From:
Sent: 11 May 2026 15:41
To: DC Admin
Subject: Planning application 2026/90930

Please find below comments regarding the proposed extension at 349 Whitehall Road, Wyke, BD12 9DP.

Issue Purpose : Planning Application  
Client N/A  
Project N/A  
Address 349 Whitehall Road, Wyke, Bradford BD12 9DP  
Title Existing and Proposed Plans

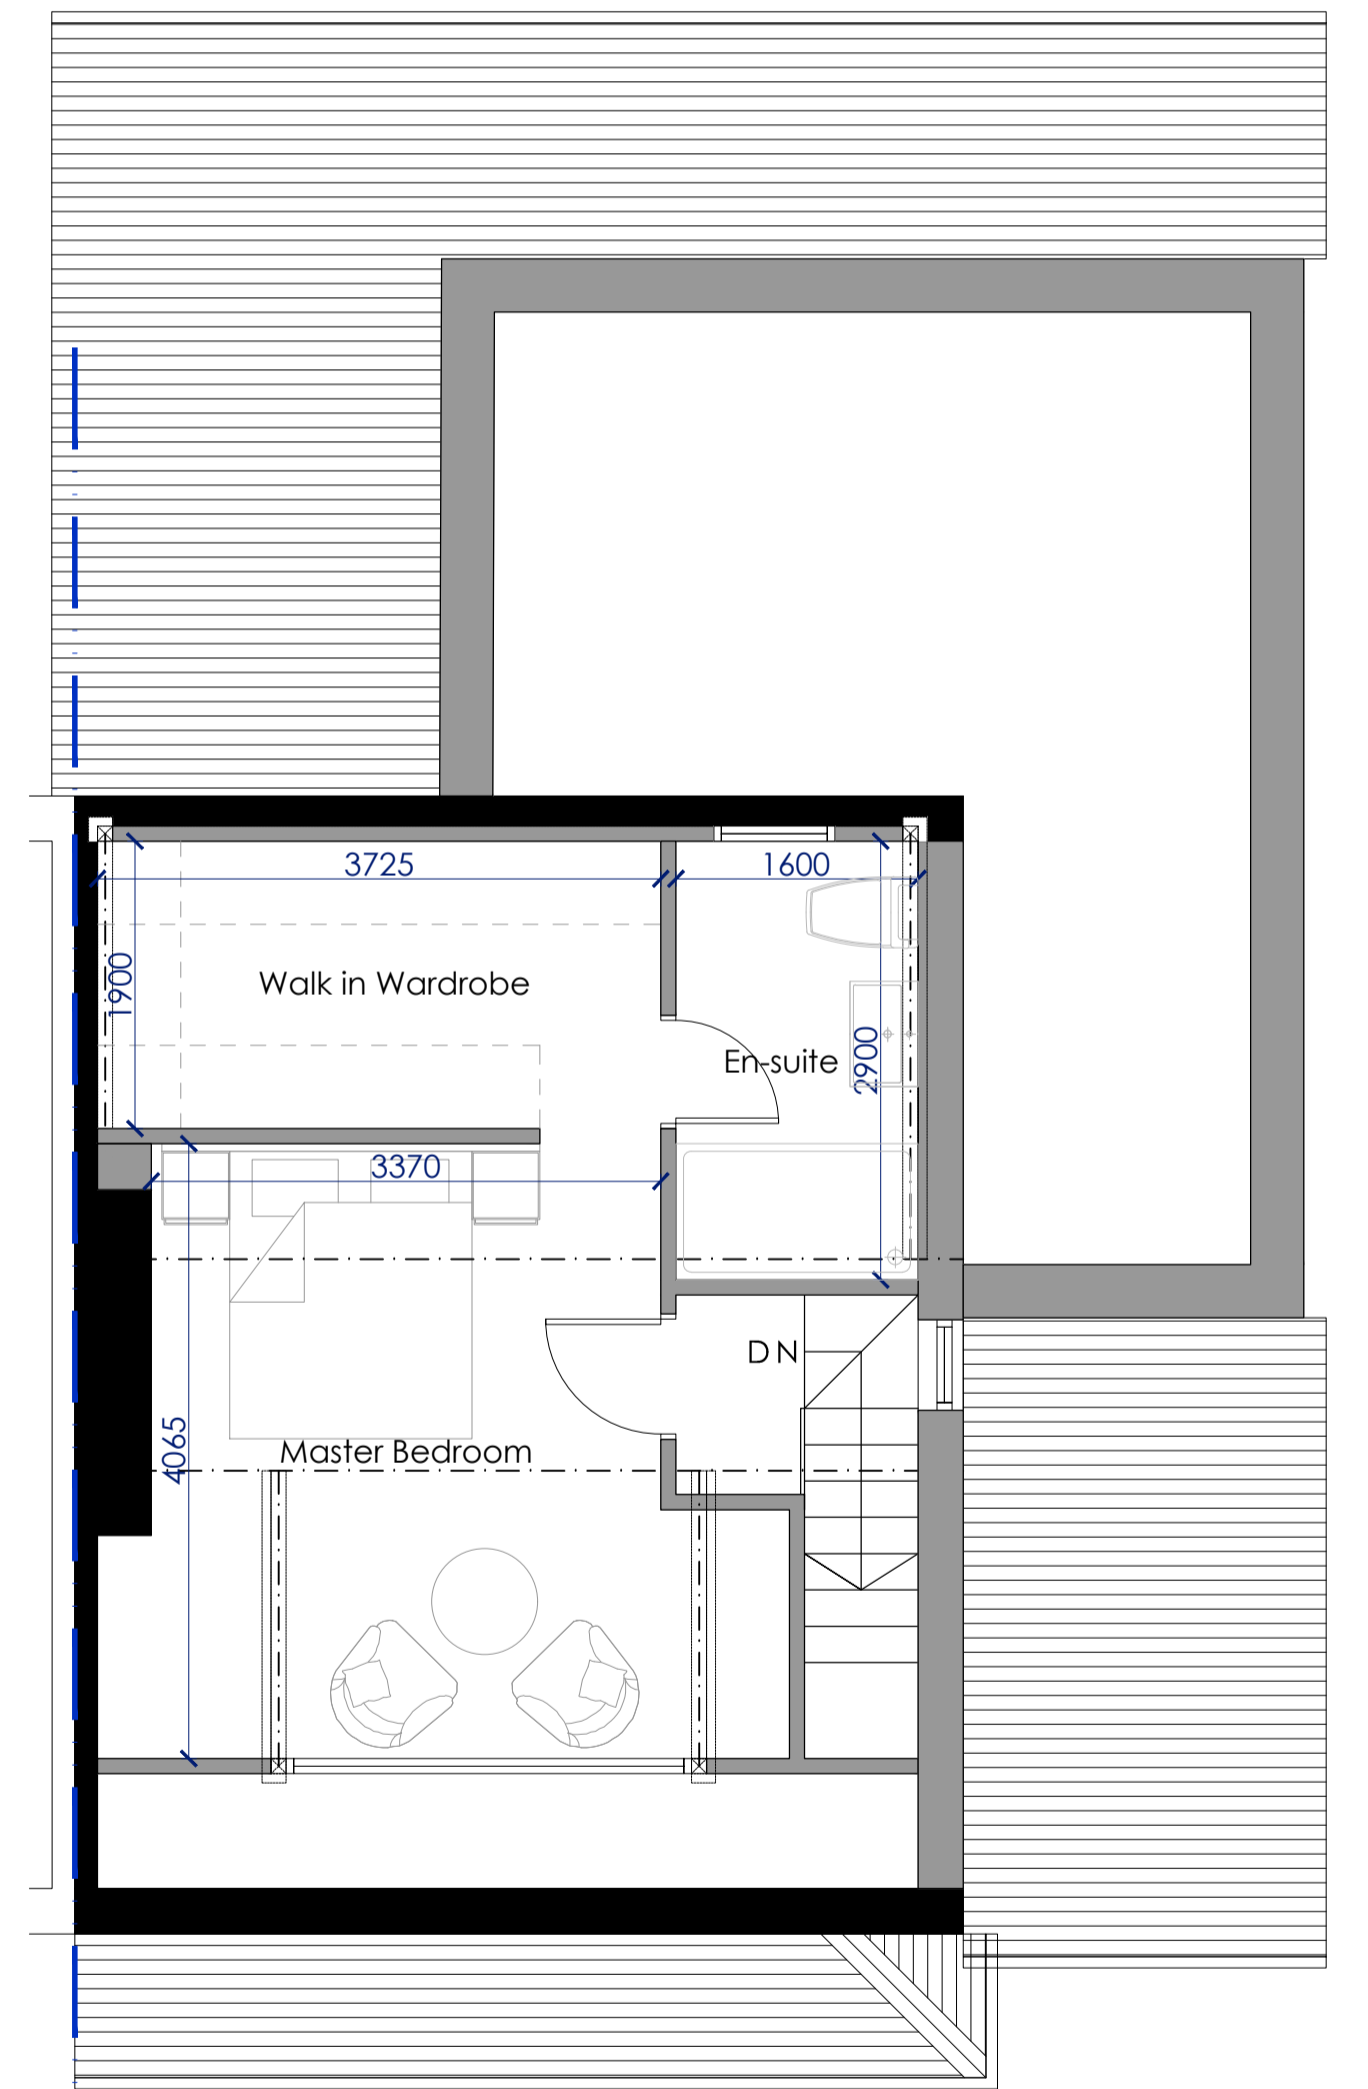
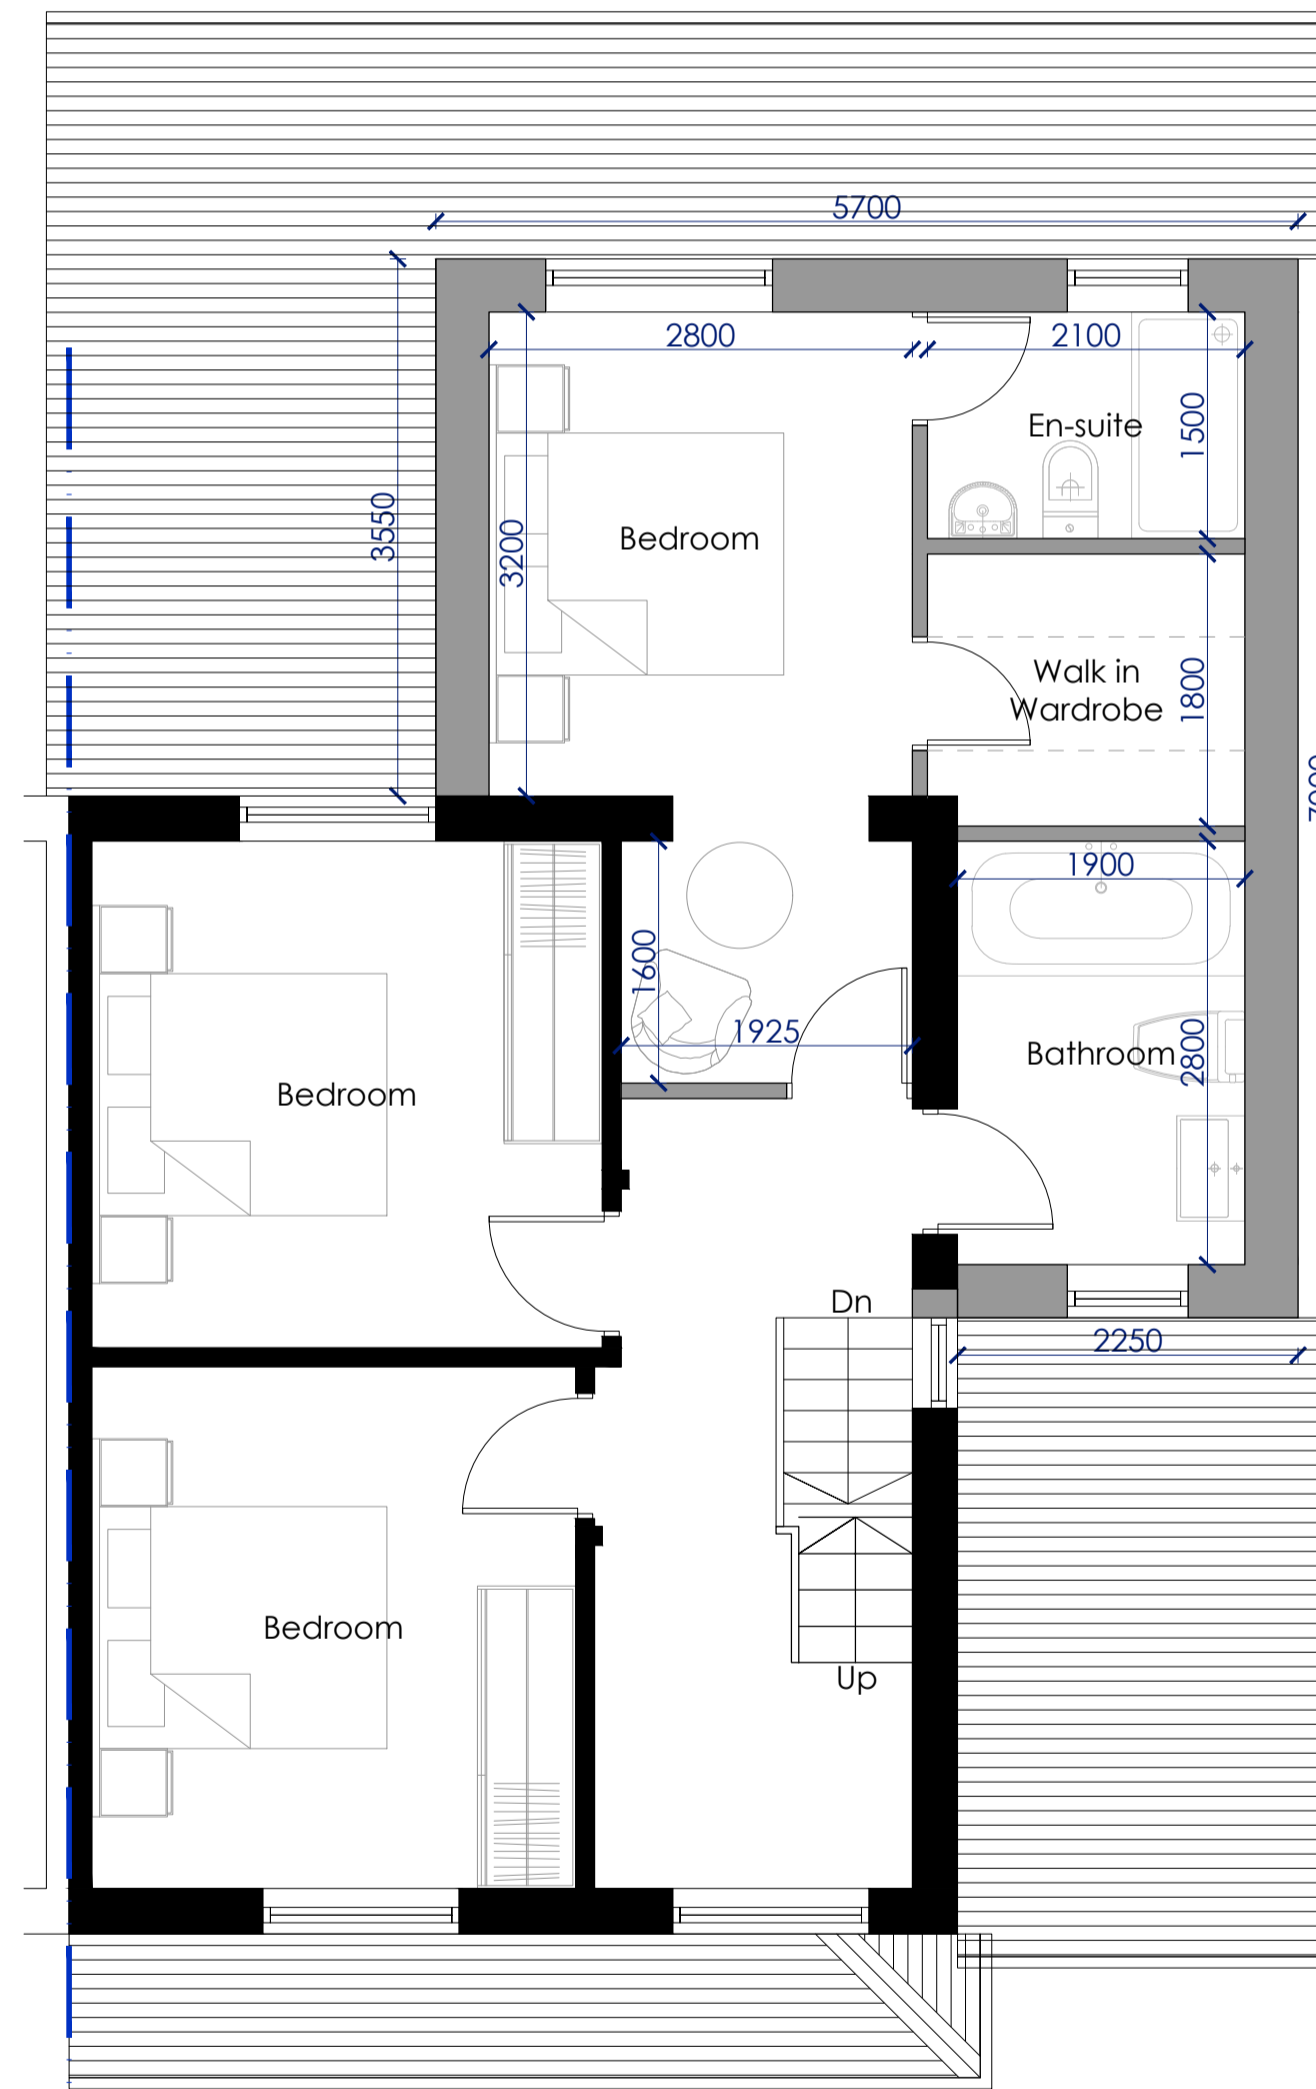
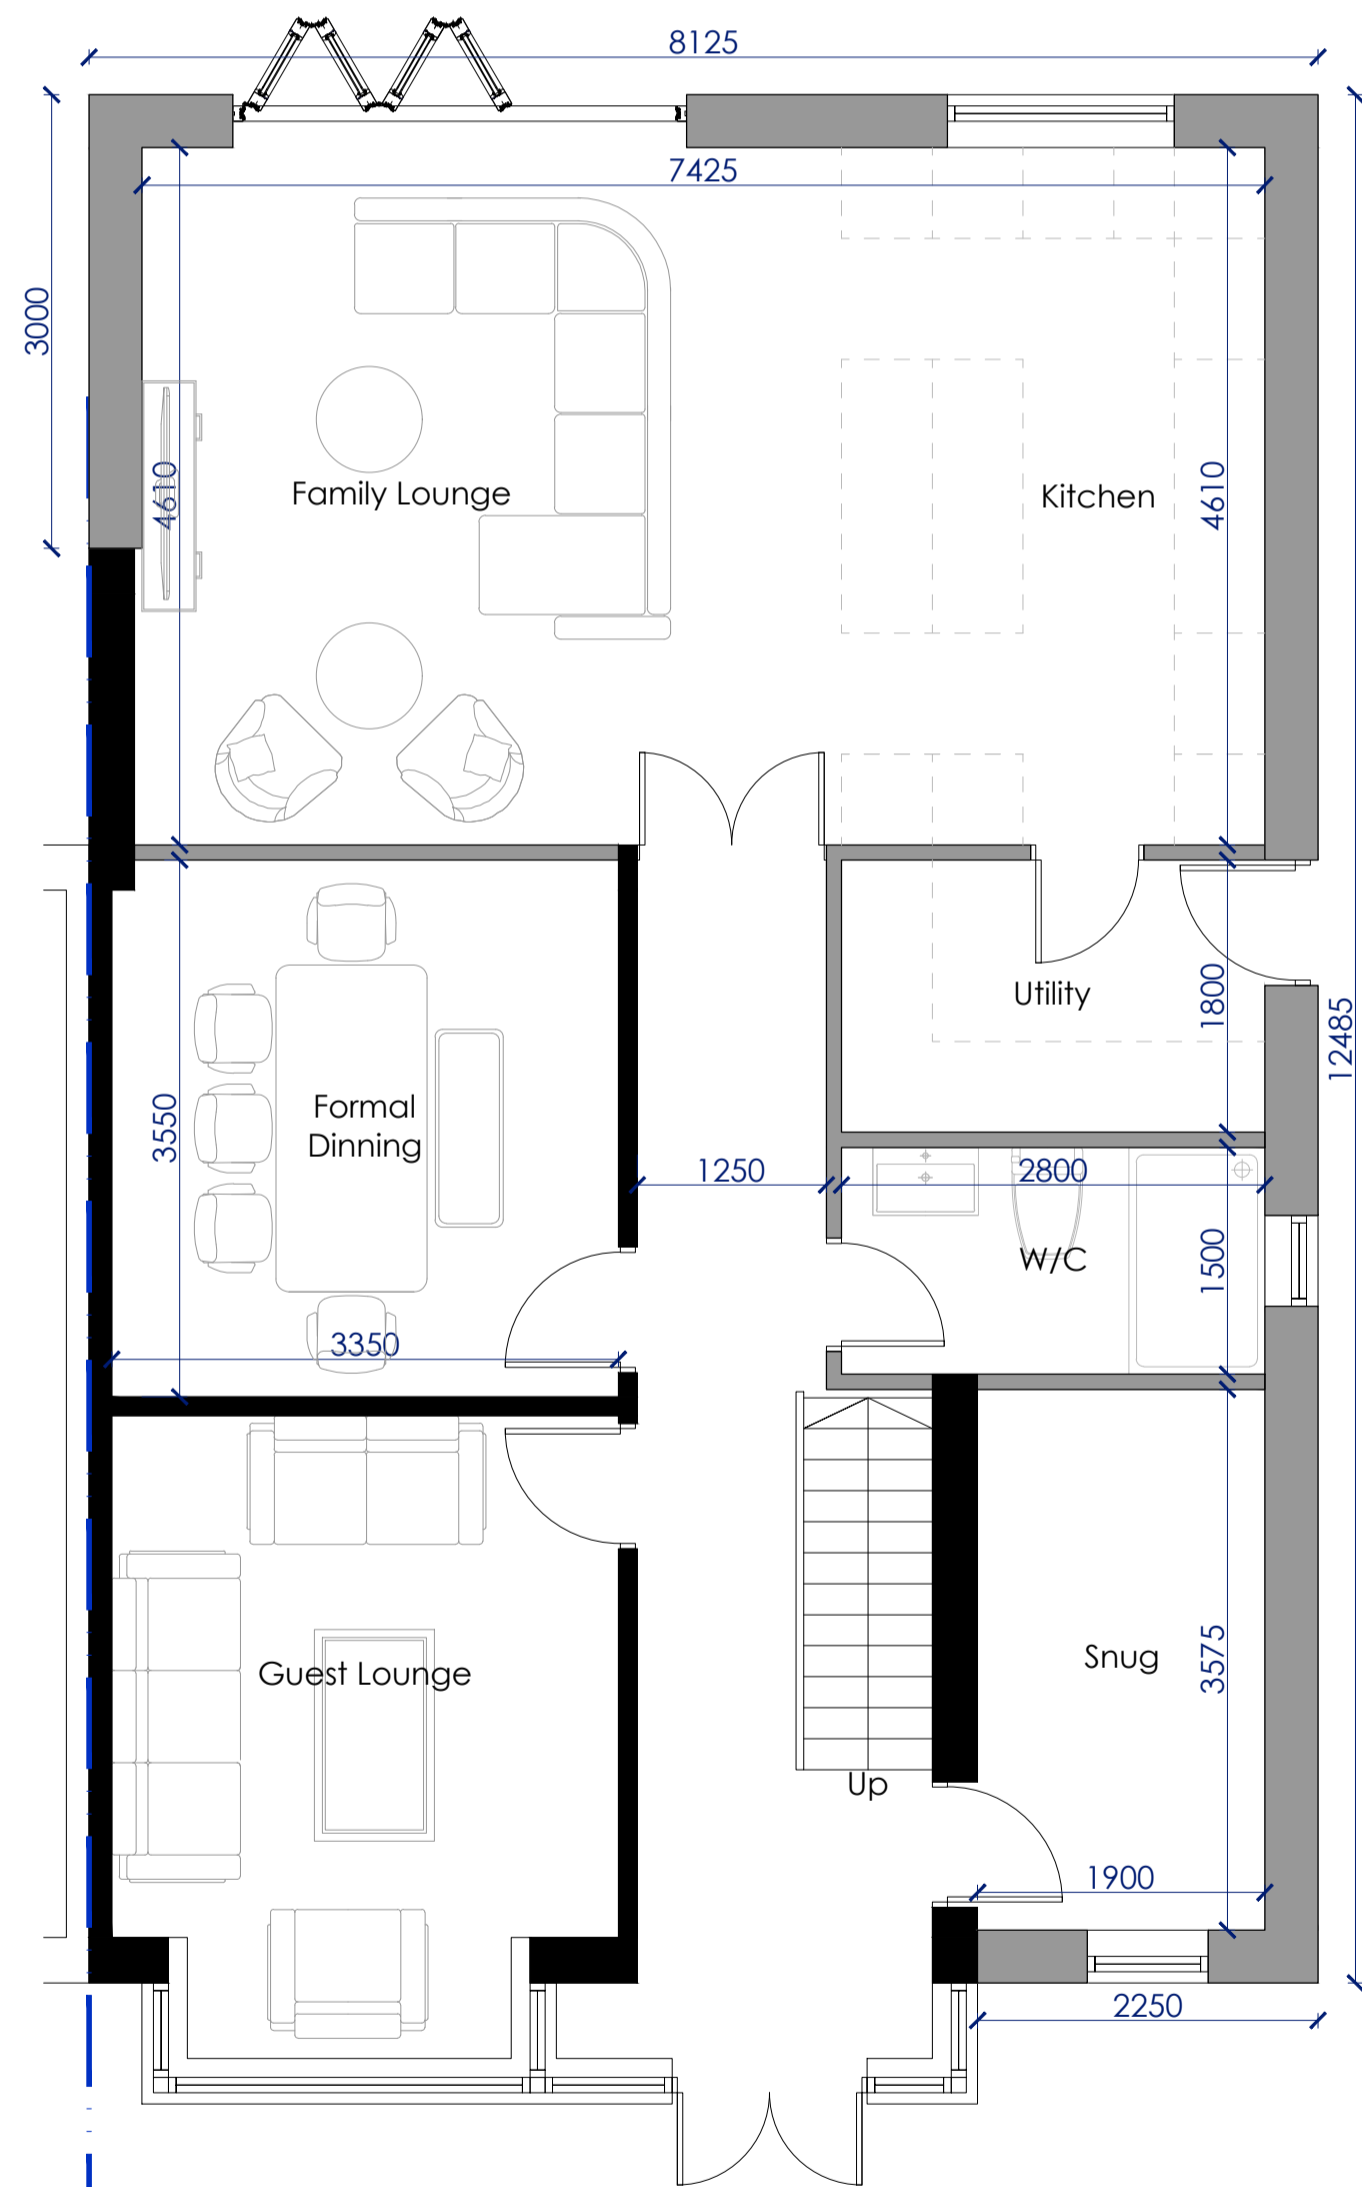
The number of bedrooms shown on the plans is a 4 possibly 5 bedroomed house (if the walk in wardrobes are used as bedrooms once completed). If the residents own several vehicles there is insufficient room on the drive to park these and again will impact the neighbours. Outside of 349 is a lamp post which makes it difficult to park on the road directly in front of this house, meaning the residents may park in front of the neighbours' houses obstructing the view of traffic when gaining access in and out. This will cause both frustration and be dangerous as we all need the ability to easily gain access in and out of our properties in a safe way. Whilst I appreciate you cannot legally stop people from parking directly outside of your property it will likely result in arguments. This is why the existing residents opened their driveway up to park the 2 vehicles they owned.
